CITY OF ALBUQUERQUE

RE: **Lot 3 Block 9 S.A.D. 227 Unit 28**
6212 Kayenta Dr. NW
Grading and Drainage Plan
Engineers Stamp Date 1/3/20 (E10D074)

RE: **Lot 3 Block 9 Unit 5 SAD 227**
Unser Cliffs
6212 Kayenta Dr. NW
Grading and Drainage Plan
Engineers Stamp Date 12/30/19 (E10D647)

ENGINEER'S SEAL	6212 KEYENTA PLACE	DRAWN BY DEM
DAVID SOULE NEW MEXICO 14522 REGISTERED PROFESSIONAL ENGINEER	GRADING AND DRAINAGE PLAN	DATE 12-29-19
12/30/19		6212 KEYENTA PLACE.DWG
DAVID SOULE P.E. #14522	1606 CENTRAL AVENUE SE SUITE 201 ALBUQUERQUE, NM 87106 (505) 972-0899	SHEET # C1
		JOB #

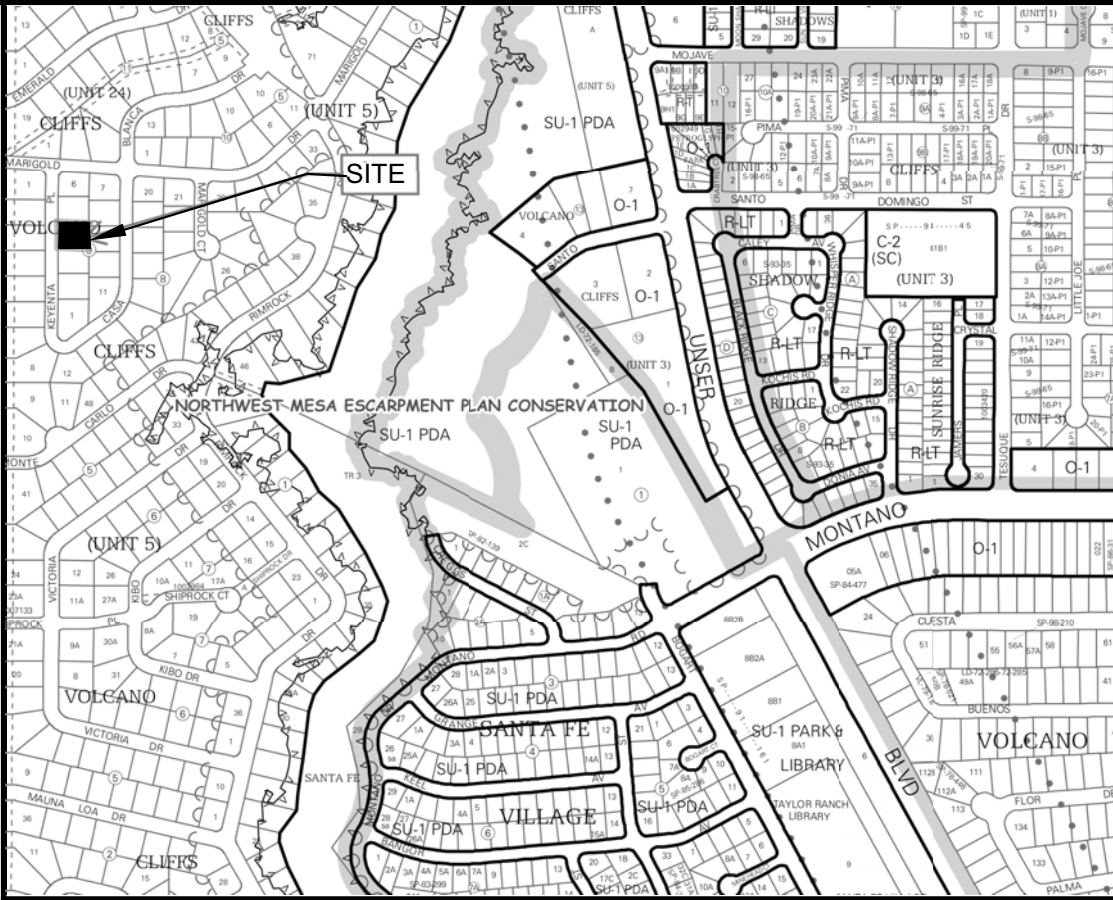
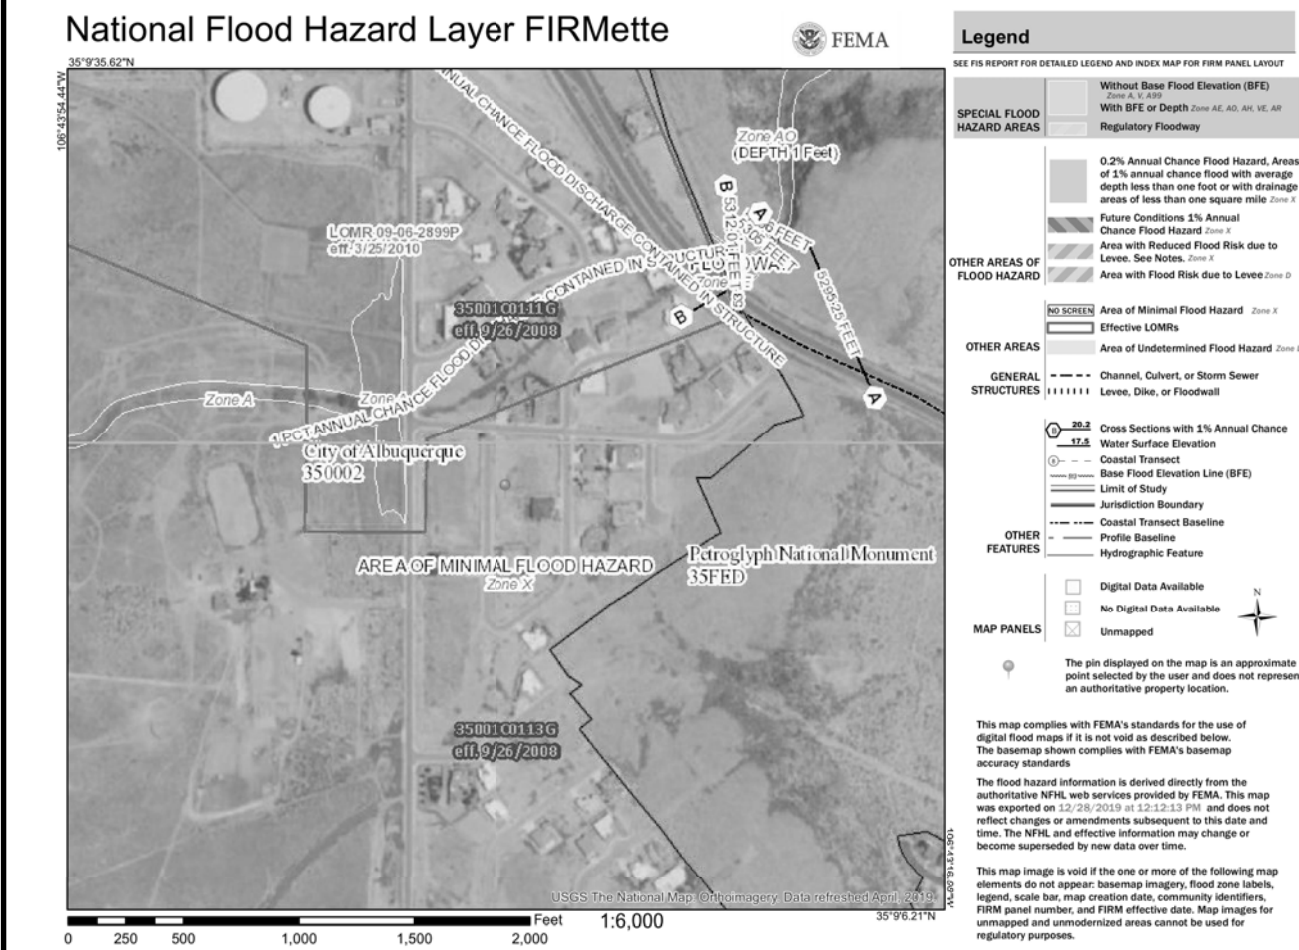
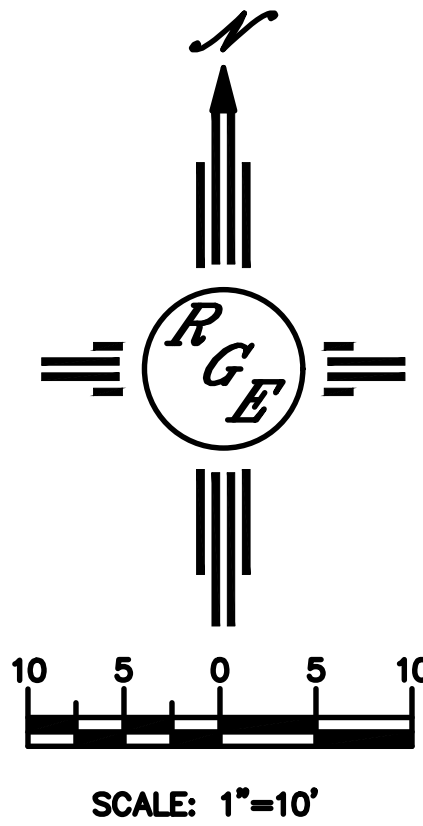
- Make all flows exit out onto Kayenta Dr.
- Inform Owner/Contractor not to use dirt as a ramp to climb curbing or drive over the sidewalk. Only crusher fines or lumber may be used for this process.
